Application for Removal or Variation of a Condition following Grant of Planning Permission or Listed Building Consent

Blunts Avenue

Erection of part single storey, part two storey side and rear extension.

12171/APP/2024/2831

Roof Plan Proposed

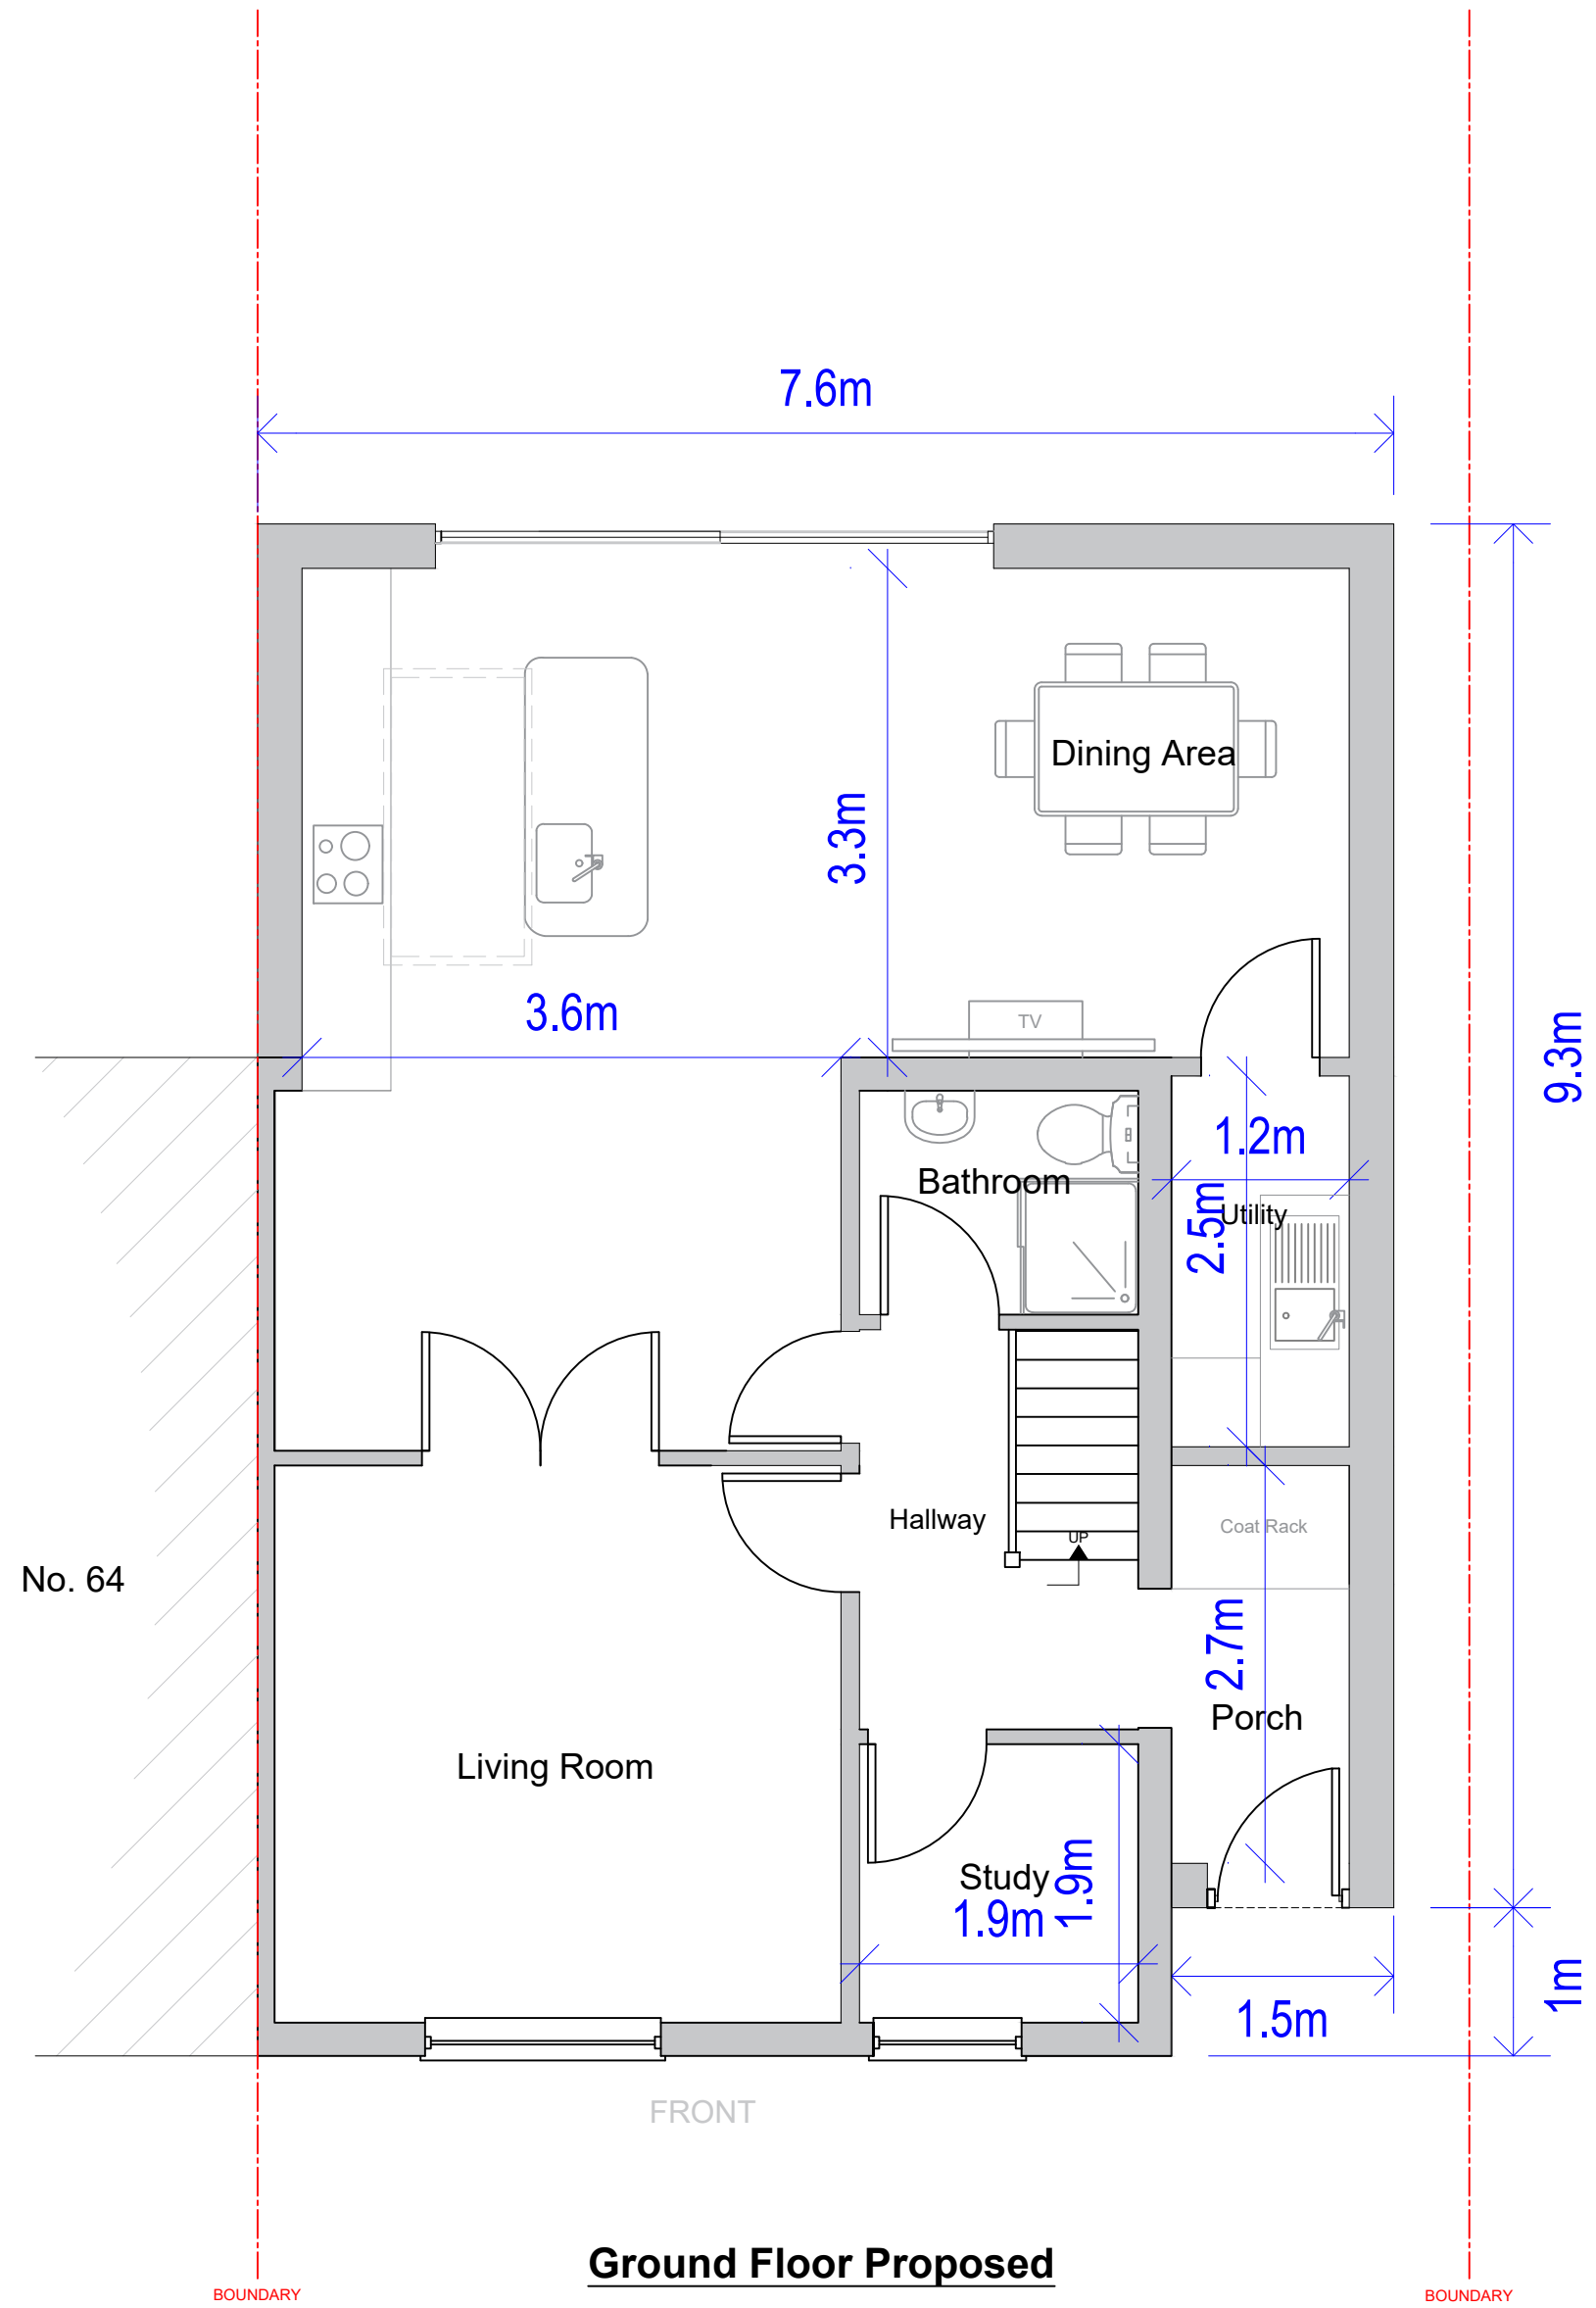
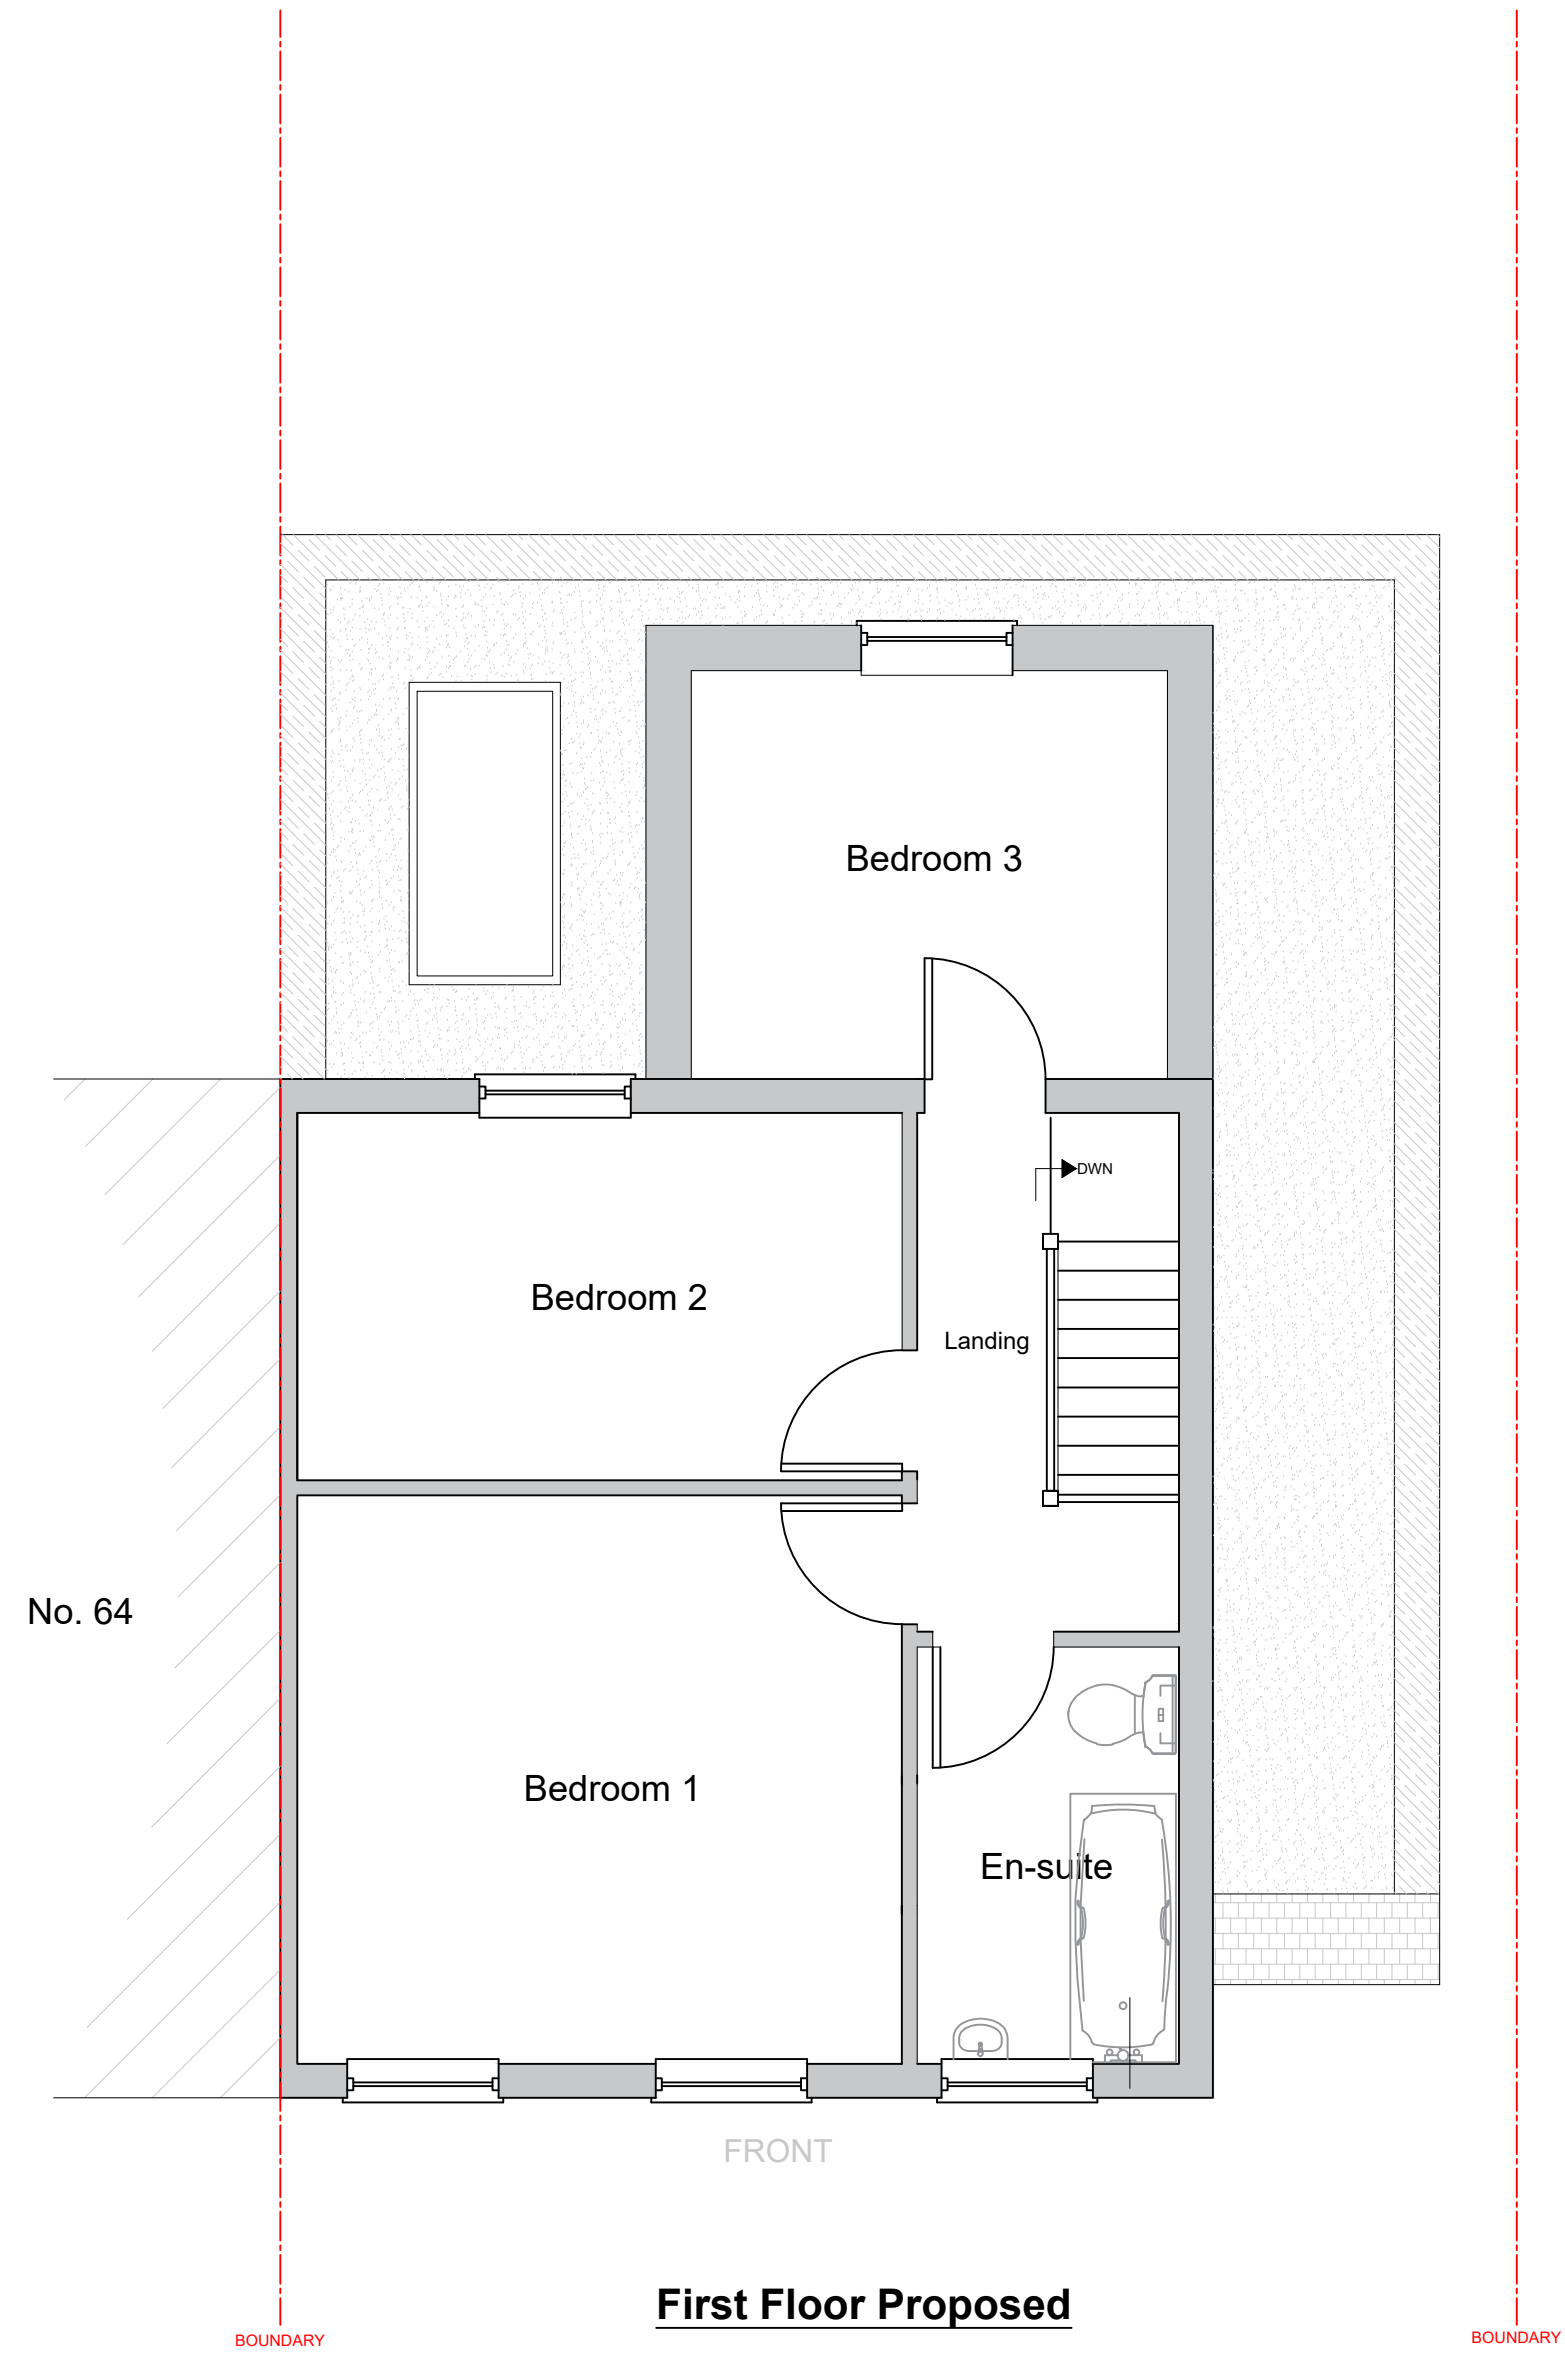
We would like to replace flat roof to proposed first floor rear extension with pitched gable roof

We do not have enough headroom in new bedroom and would like to provide vaulted ceilings to address this
